STATE OF NORTH CAROLINA
DEPARTMENT OF TRANSPORTATION

Addendum No. 1

RE: Contract # C204657

I-26 FROM MILE MARKER 62.5 TO MILE MARKER 64

PROJECT REFERENCE NO. 15614.1075010	SHEET NO. 2D-33
HYDRAULICS ENGINEER	
DOCUMENT NOT CONSIDERED FINAL UNLESS ALL SIGNATURES COMPLETED	
TGS ENGINEERS 804-C N. LAFAYETTE ST SHELBY, NC 28150 PH (704) 476-0003 CORP. LICENSE NO.: C-0275

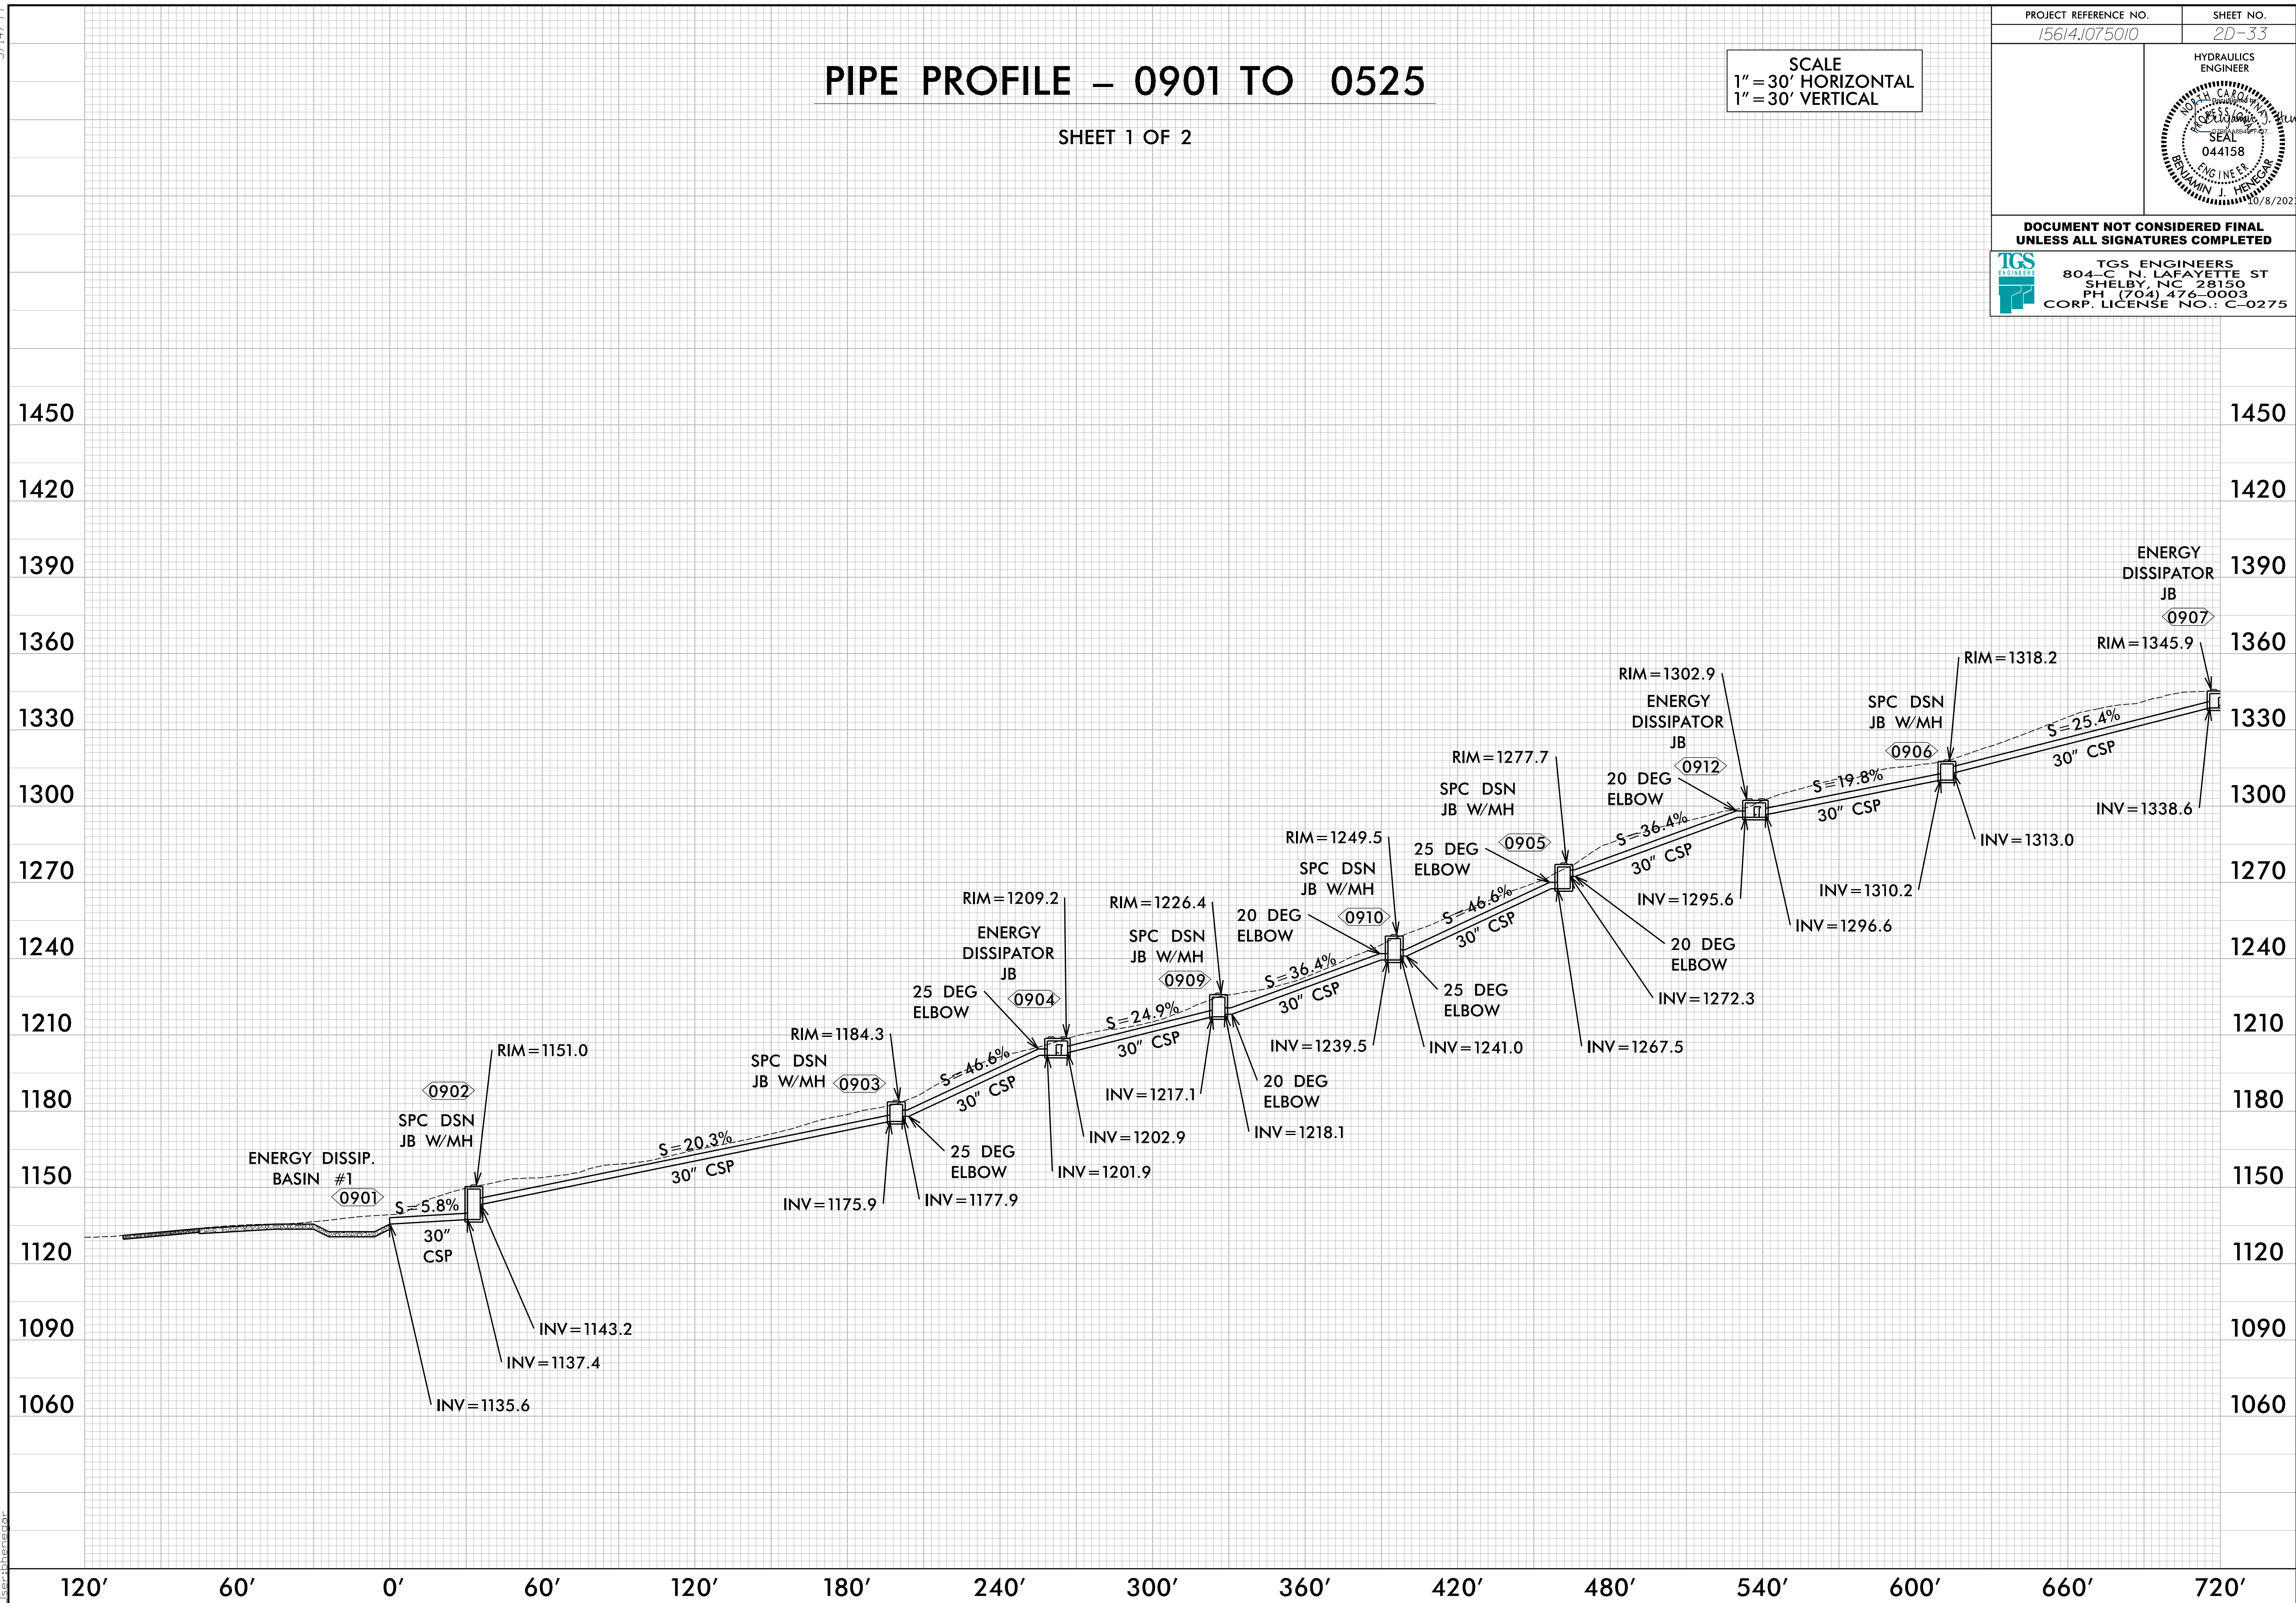
Sheet No.	Revision
2D-33	Removed SA boundary from pipe profile.
2D-35	Removed pipe lining from pipe profile. (0602 to 0542)
3D-2	Removed 156 LF of 36" Pipe Rehabilitation CIPP Liner from drainage summary. (0602 to 0542)
3D-6	Updated project totals for removal of 156 LF of 36" Pipe Rehabilitation CIPP Liner.
4	Added shading and note for allowable working area. Added note regarding the location of the existing ROW on the southern side of the alignment. Revised table to remove SA designation and added designation for allowable working area.
5	Removed "Line with CIPP" from plan view. (0602 to 0542) Added SA areas and labels to not disturb them.
6	Removed "Line with CIPP" from plan view. (0602 to 0542) Added shading and note for allowable working area. Revised table to remove SA designation and added designation for allowable working area.
7	Added shading and note for allowable working area. Revised table to remove SA designation and added designation for allowable working area.

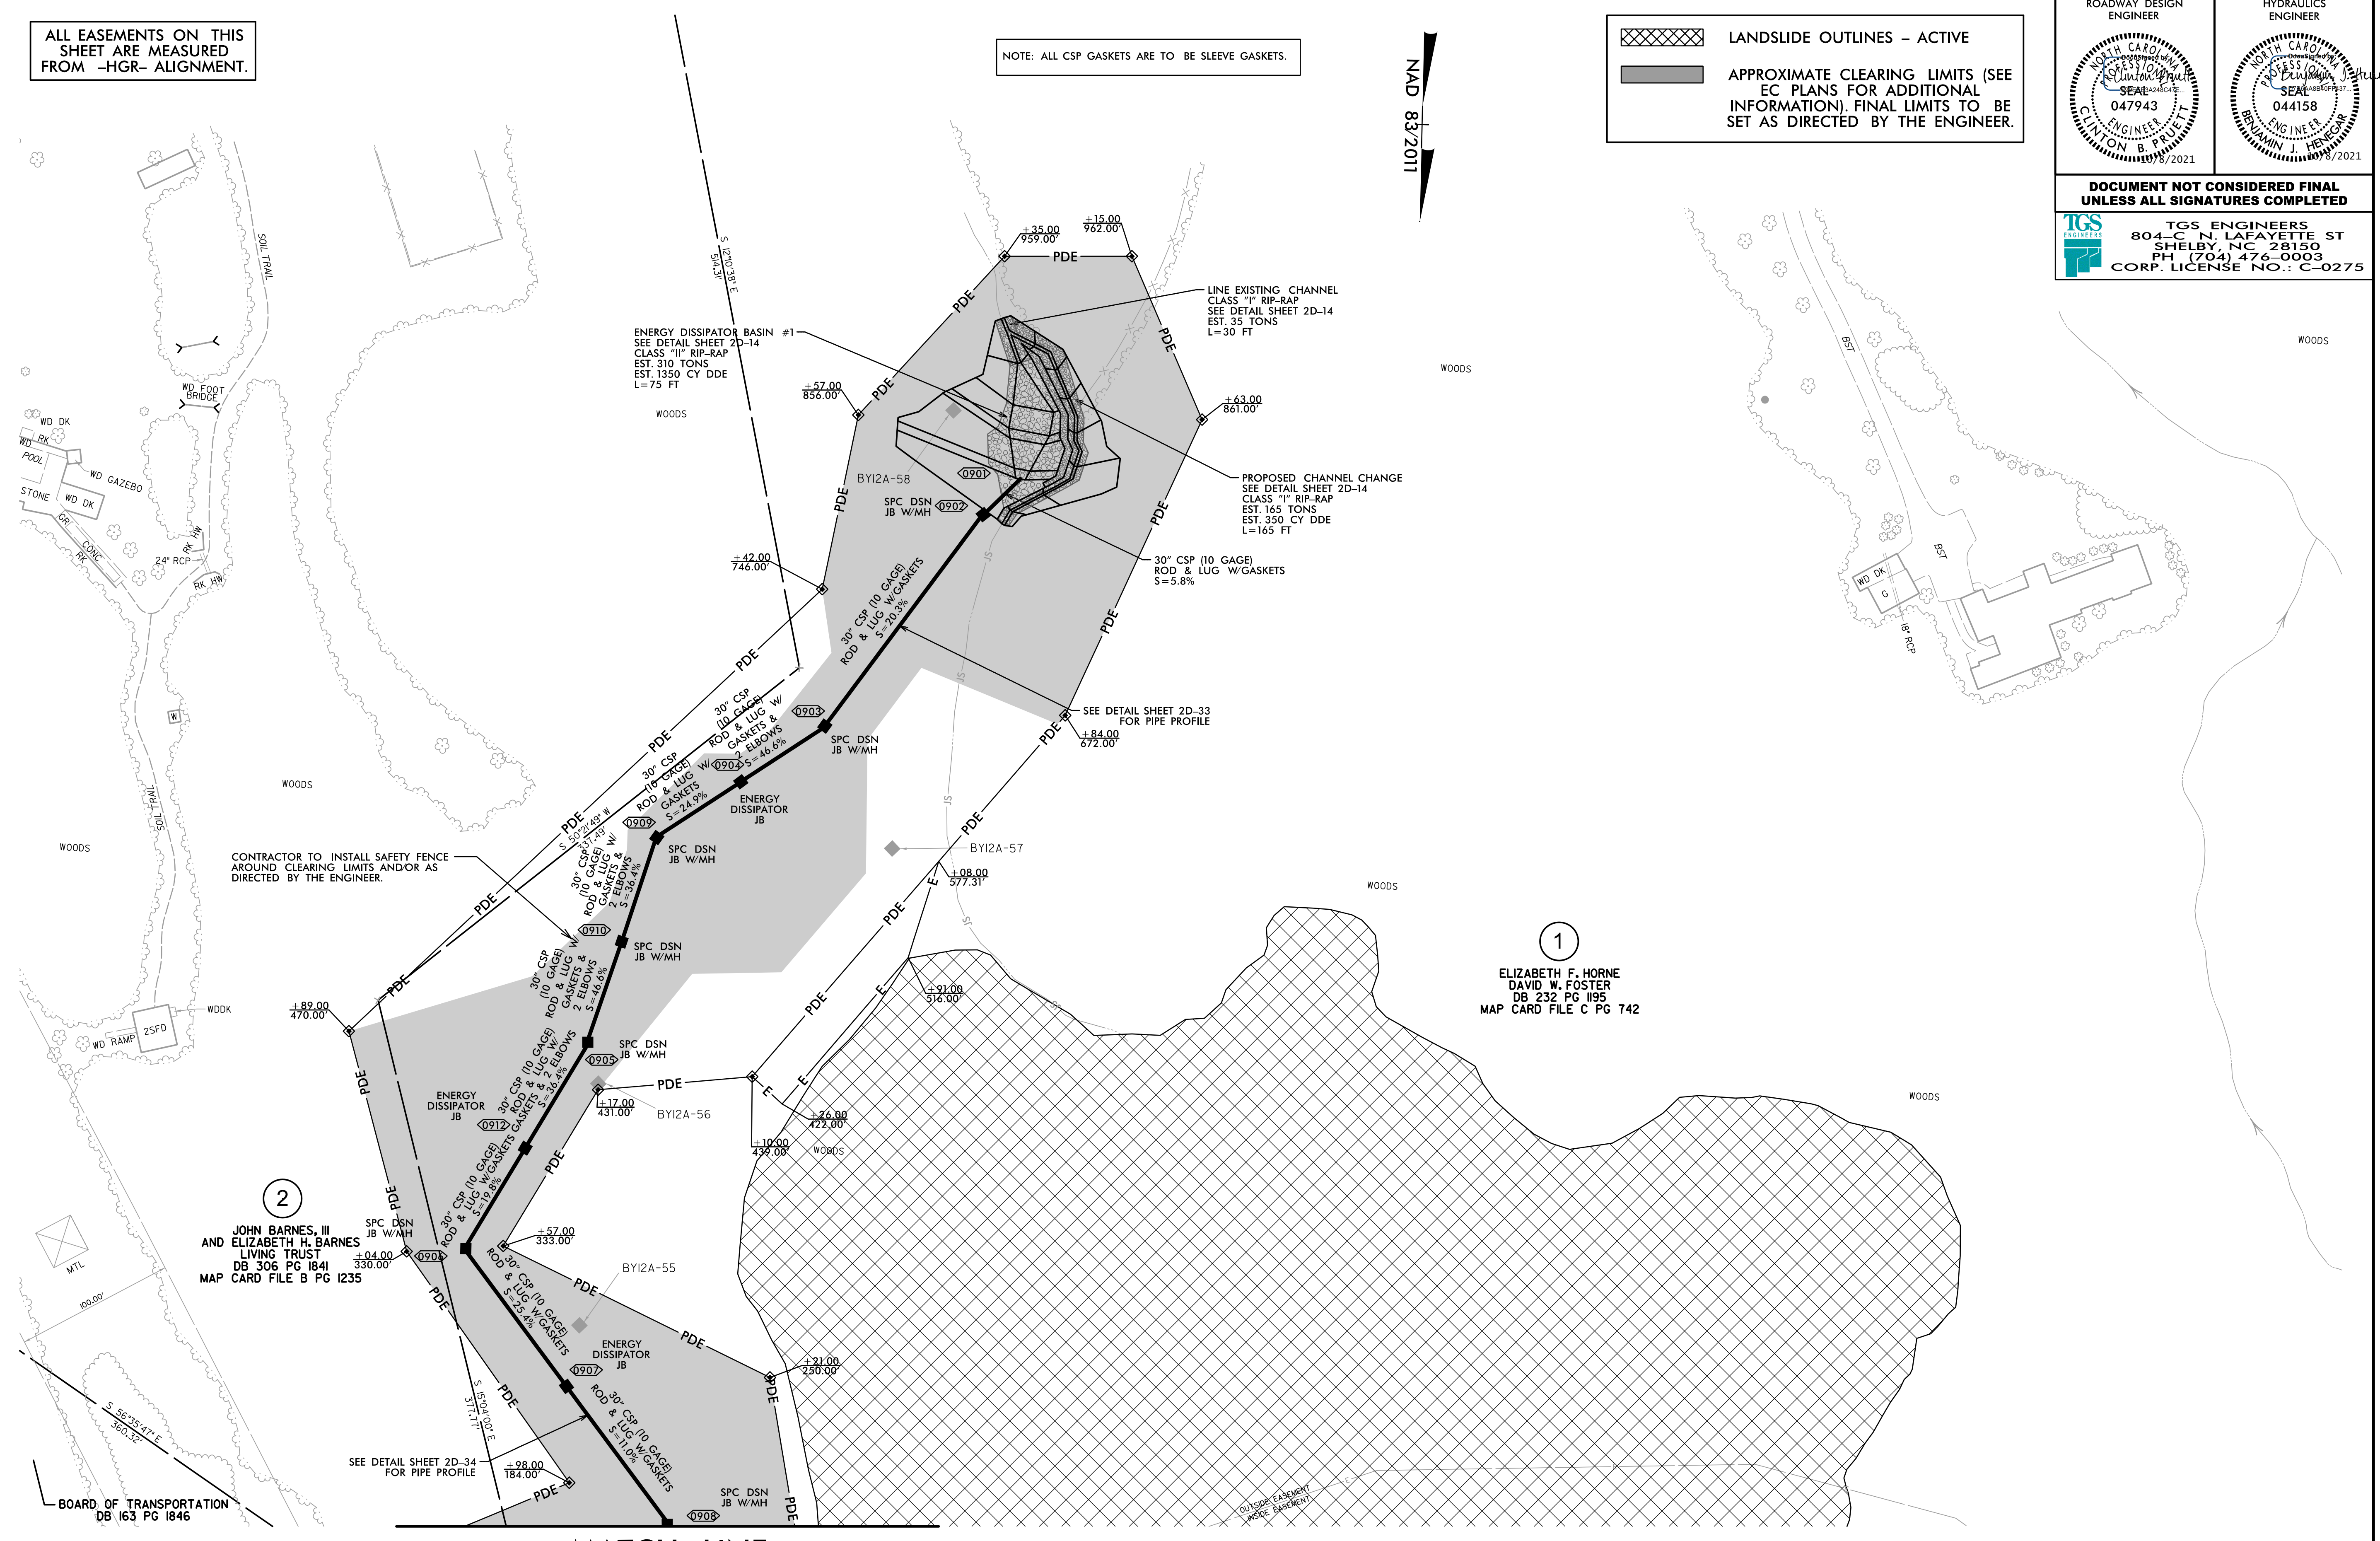
9	Revised table to remove SA designation and revised note regarding the clearing limits.
EC-4	Added safety fence -I26- 415+00 to 417+00 LT & RT. Removed SA legend. Added note regarding the location of the existing ROW on the southern side of the alignment.
EC-5	Removed EC measures -HGR- 44+00 to 46+00 LT. Removed SA legend. Added SA areas and labels to not disturb them.
EC-6	Removed EC measures -HGR- 46+00 to 47+00 LT. Added safety fence -HGR- 50+50 to 54+00 LT & -HGR- 56+00 to 58+70 LT. Removed SA legend.
EC-7	Added safety fence -HGR- 58+70 to 62+00 LT. Removed SA legend.
EC-8	Removed SA legend.
EC-9	Removed SA boundary & legend.
EC-10	Added safety fence -I26- 415+00 to 417+00 LT & RT. Removed SA legend.
EC-11	Removed EC measures -HGR- 44+00 to 46+00 LT. Removed SA legend. Added SA areas and labels to not disturb them.
EC-12	Removed EC measures -HGR- 46+00 to 47+00 LT. Added safety fence -HGR- 50+50 to 54+00 LT & -HGR- 56+00 to 58+70 LT. Removed SA legend.
